Your Ref: OWPC21340
Our Ref: K/40/18/PL 14-11-2018
Please ask for:
Mrs A Gardner

Demolition of existing dwelling & erection of 1 No. dwelling, associated landscaping & parking (resubmission following K/11/16/PL).

Spring Tide Gorse Avenue East Preston

Proposed First Floor Plan I / 100

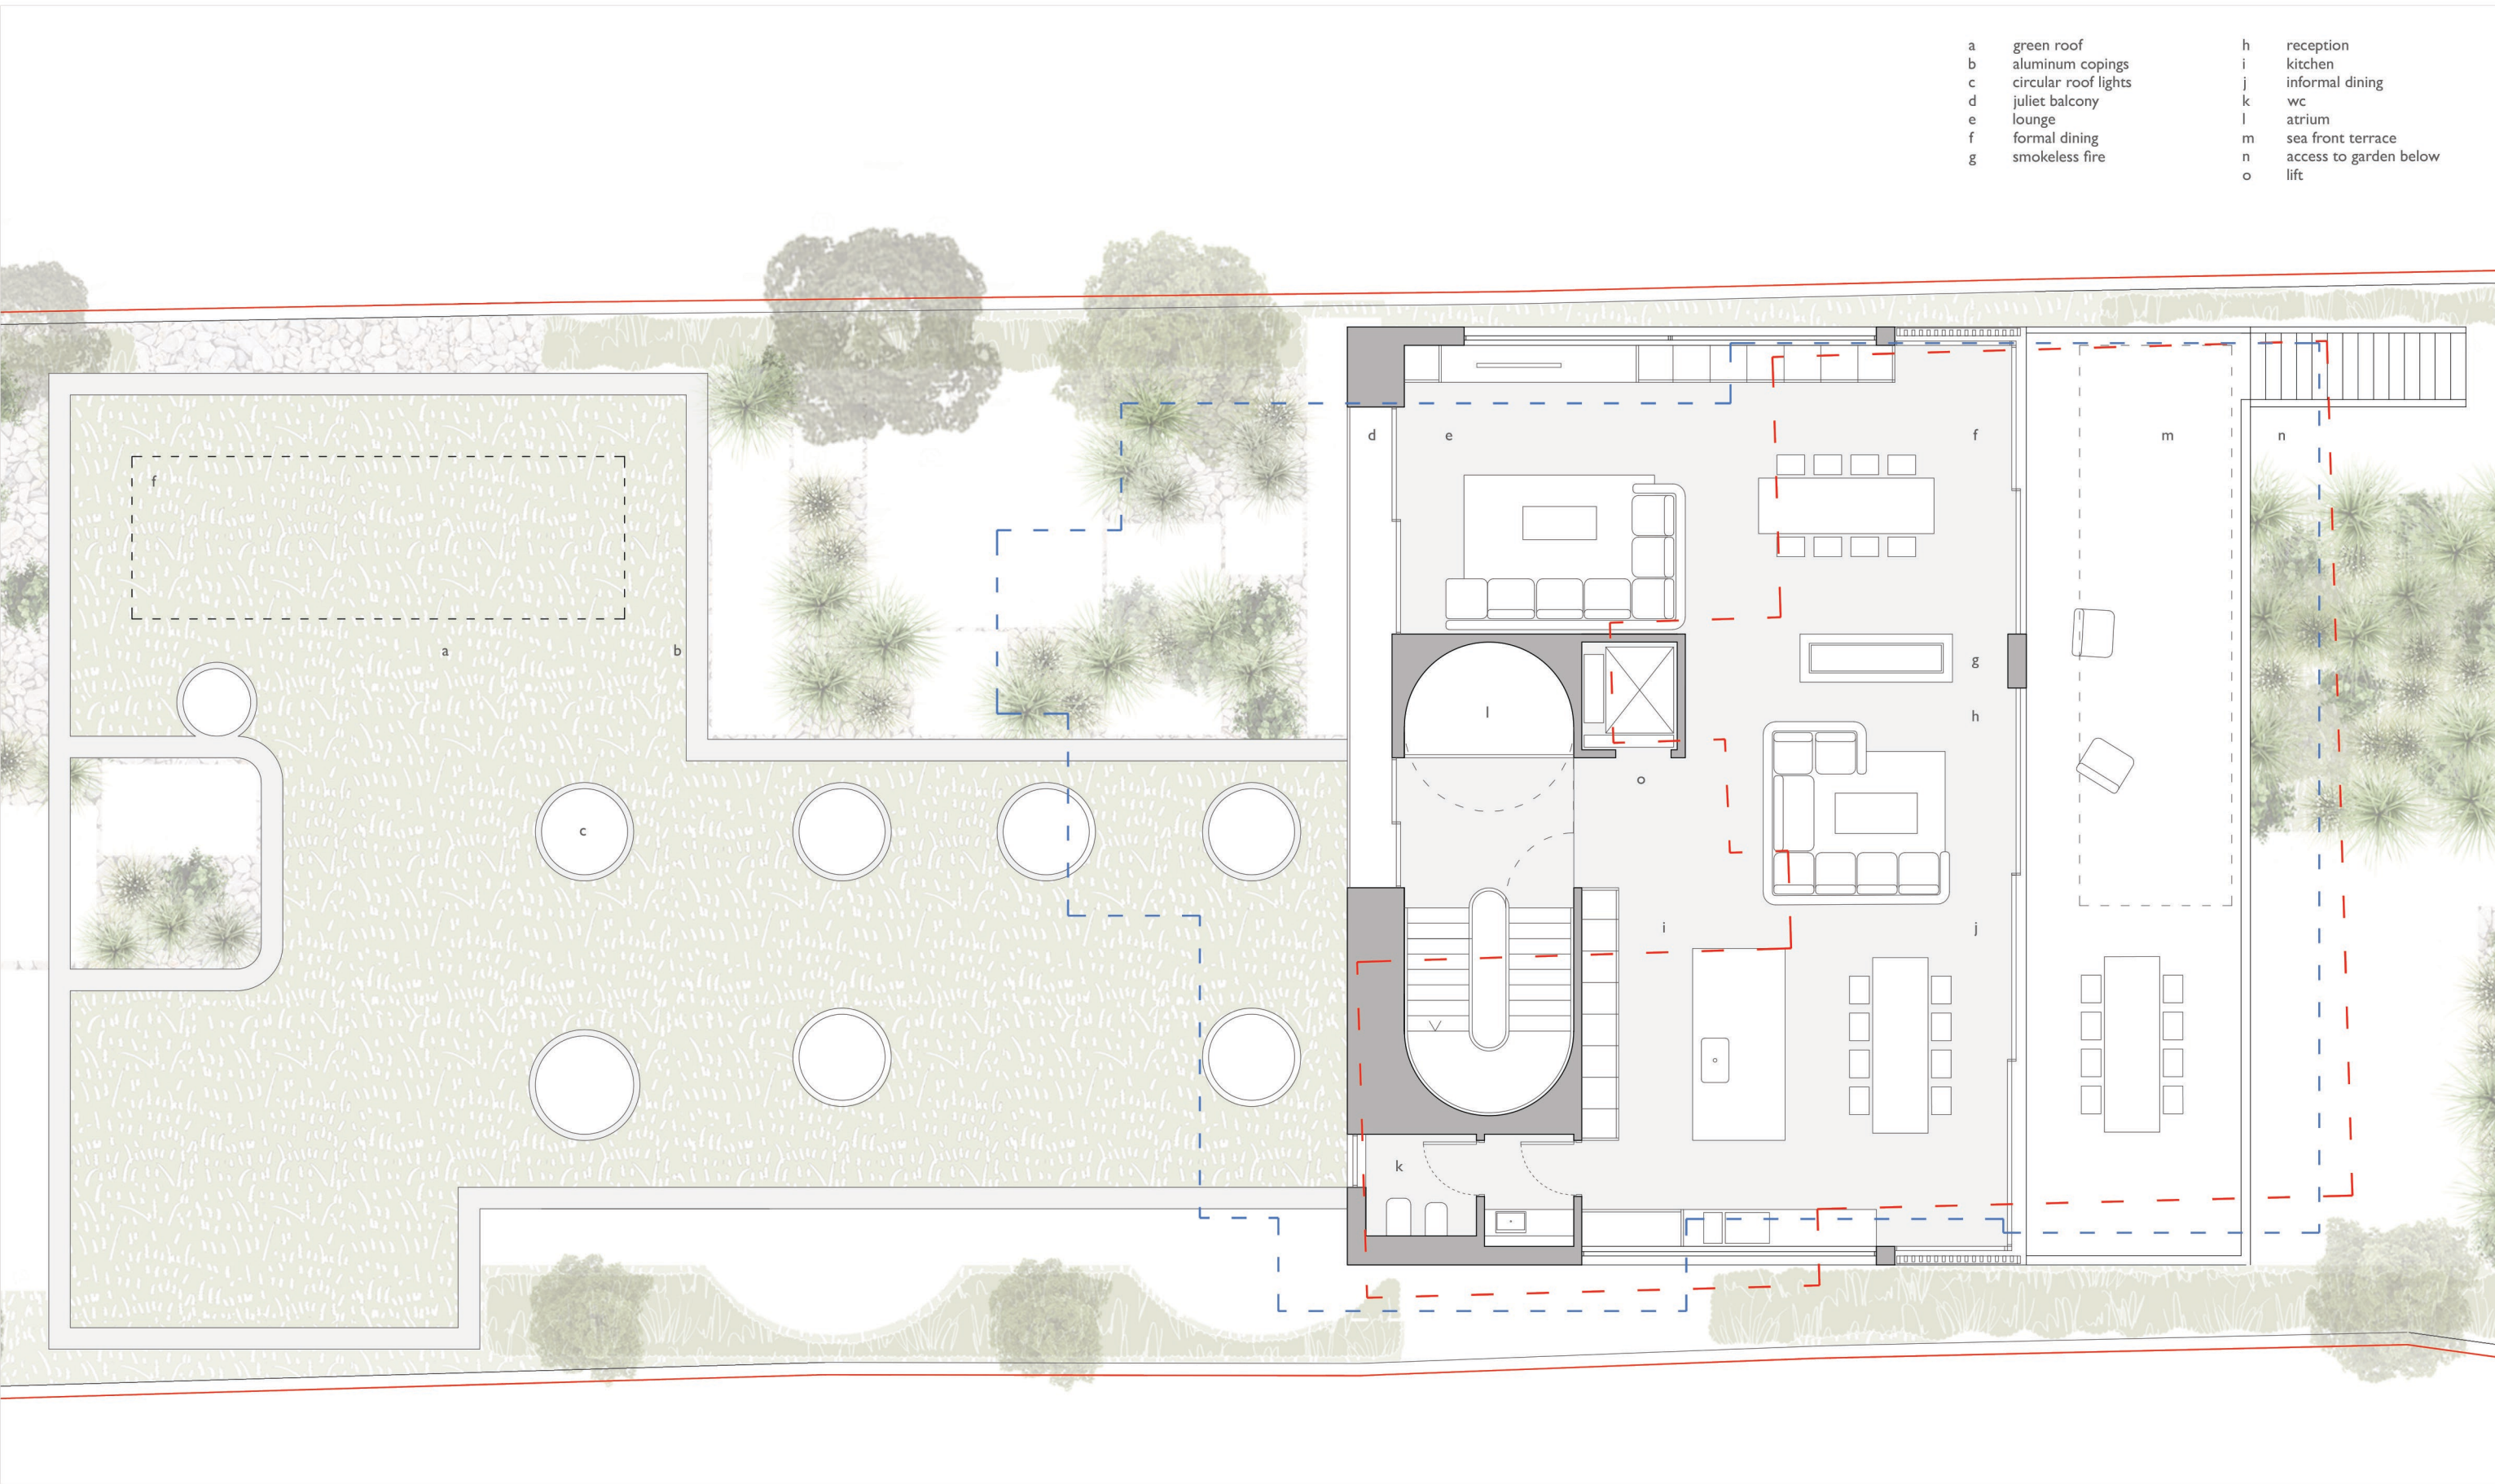
Incidentally, in commenting on objectors letters, the applicant states that there are only high level windows on the west facade at first floor, so neighbours would not be overlooked. The plans appear to show a floor length window on the western side at first floor level,
